## Application for a Non-Material Amendment Following a Grant of Planning Permission

Conversion of adjoining existing single storey barn and erection of front porch to provide main entrance, including internal alterations and changes to fenestration of dwelling.

2020/1509

Material Amendment:

Copyright © 22/Y.Dale/2.2.1

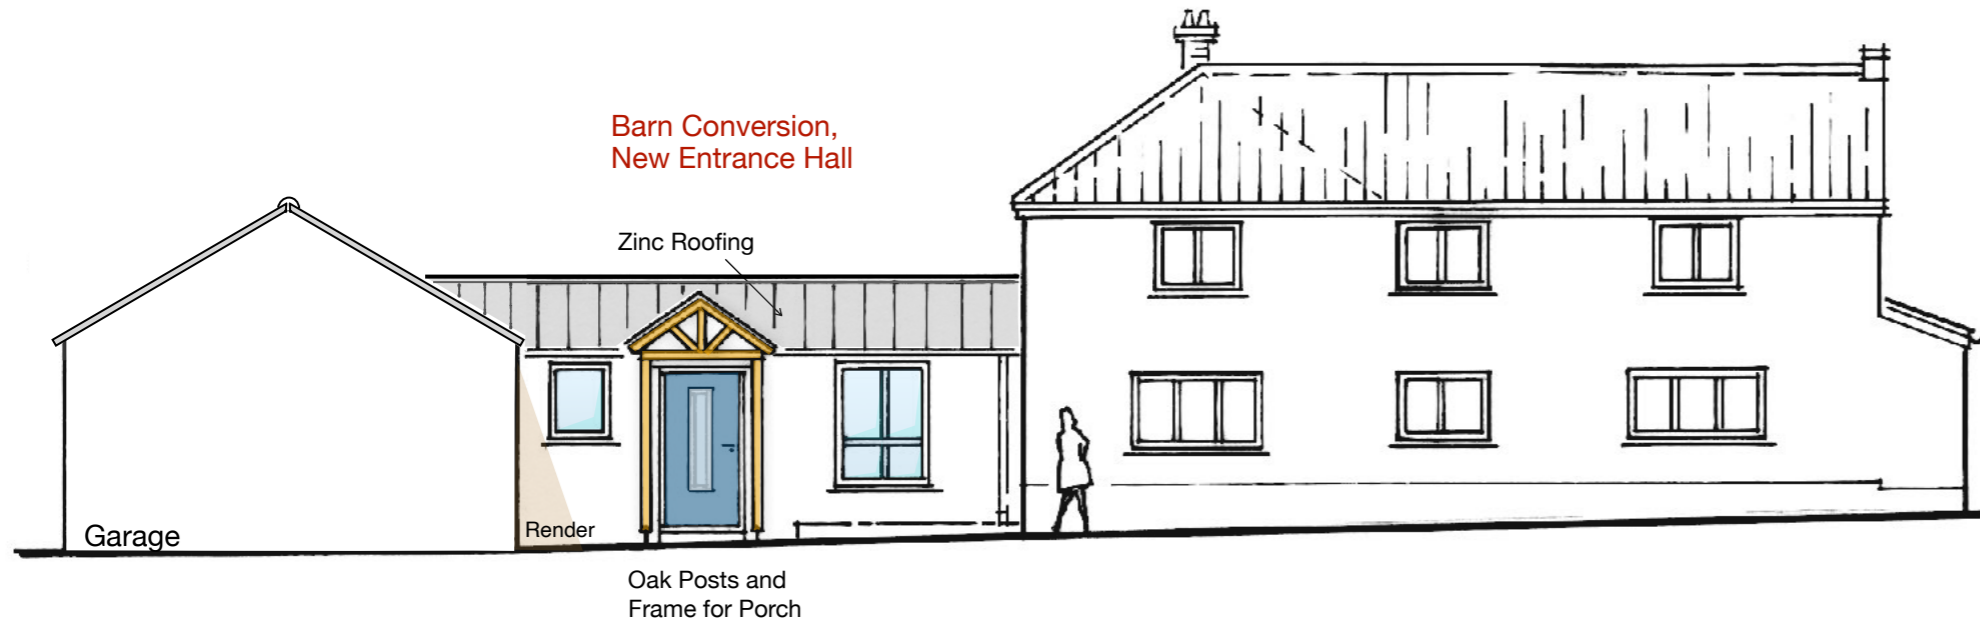
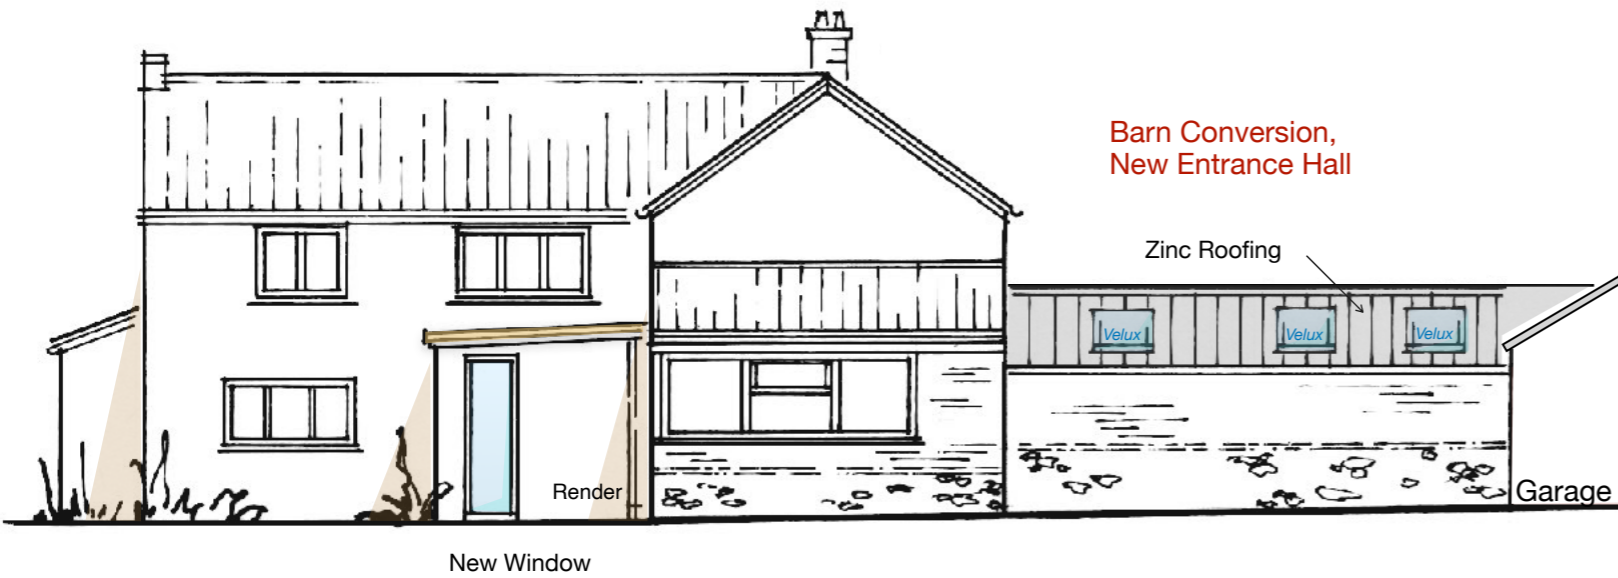
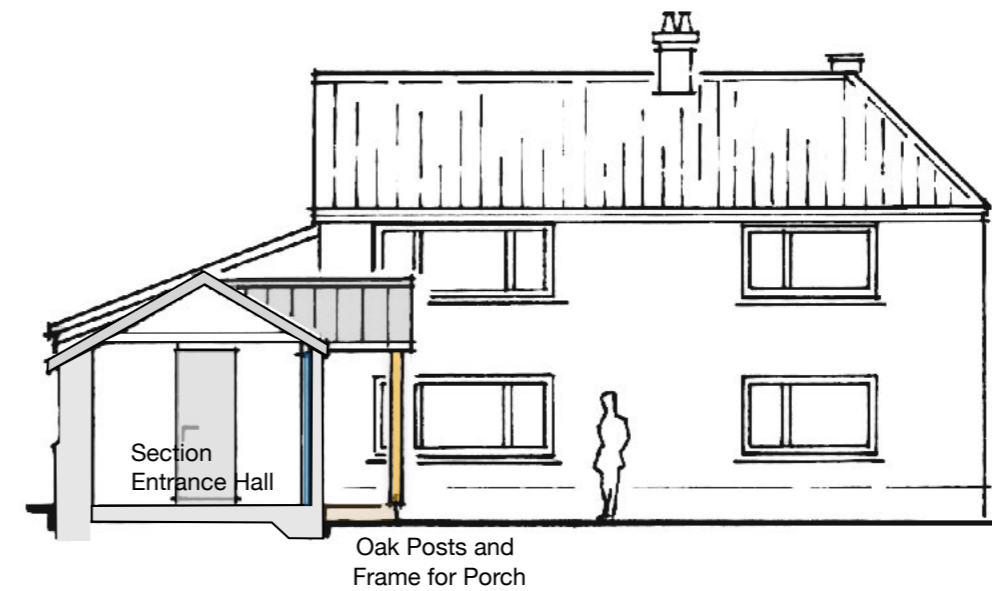
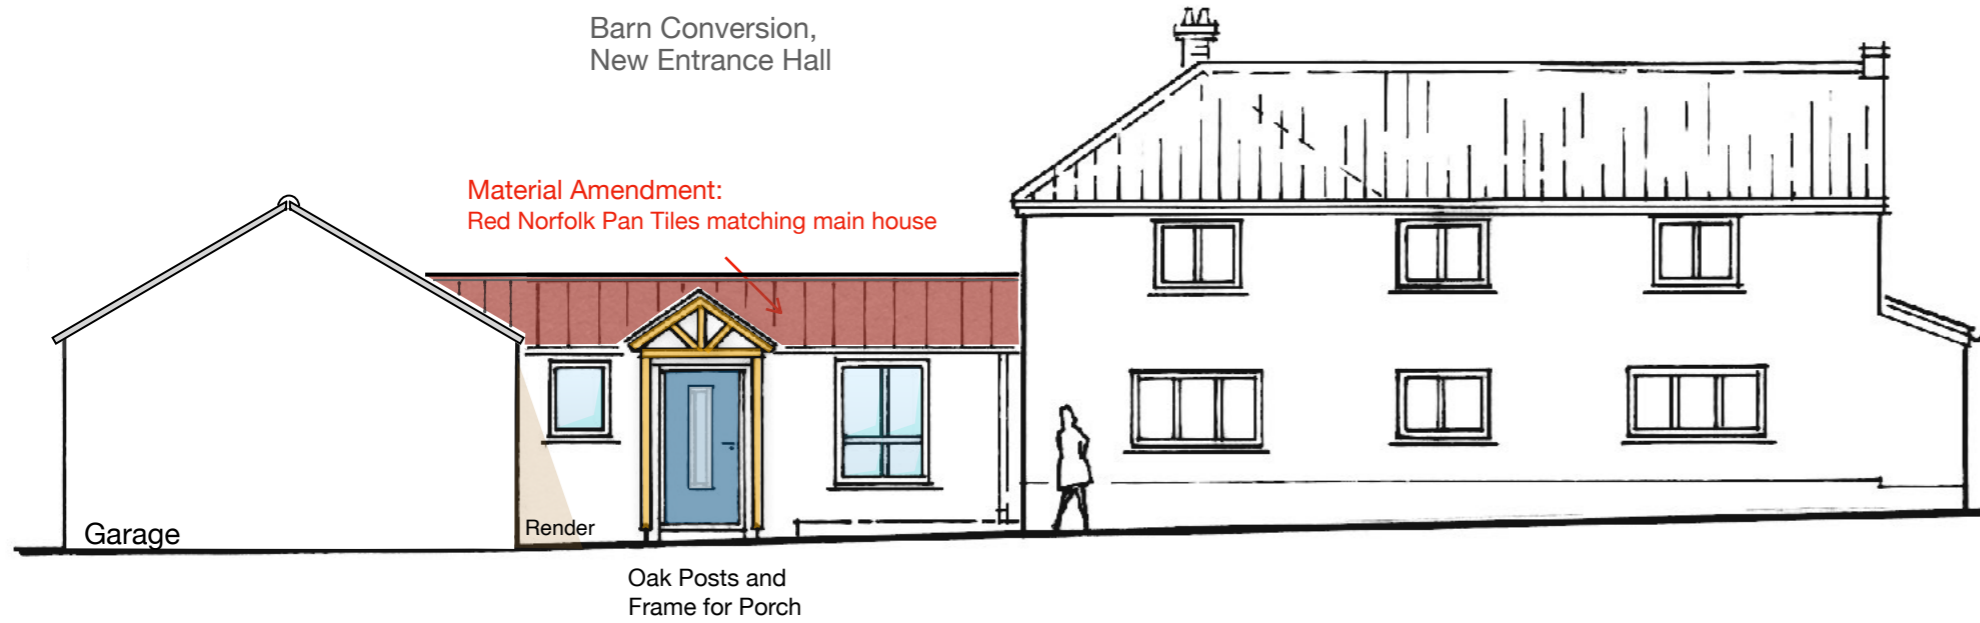
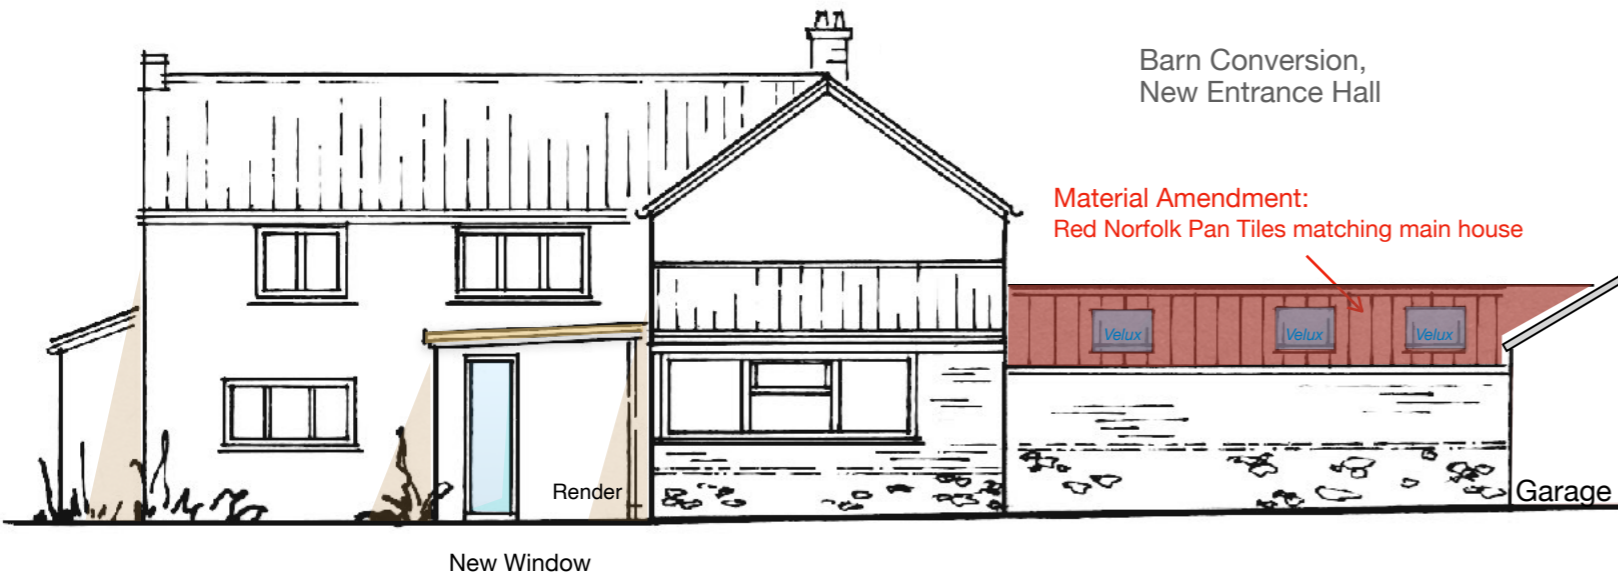
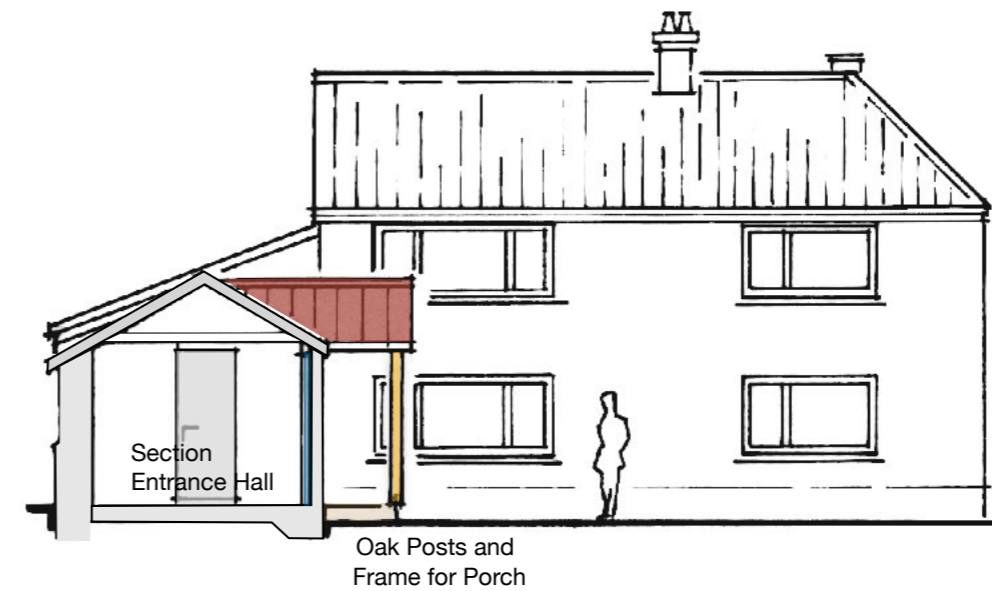
Change the roof covering of the barn conversion/new entrance hall from the approved Zink cladding to Red Norfolk Pan Tiles matching main house.

The amendment is necessary due to the costs of the Zink cladding.

Elevations - 22/Y.Dale/2.2.1
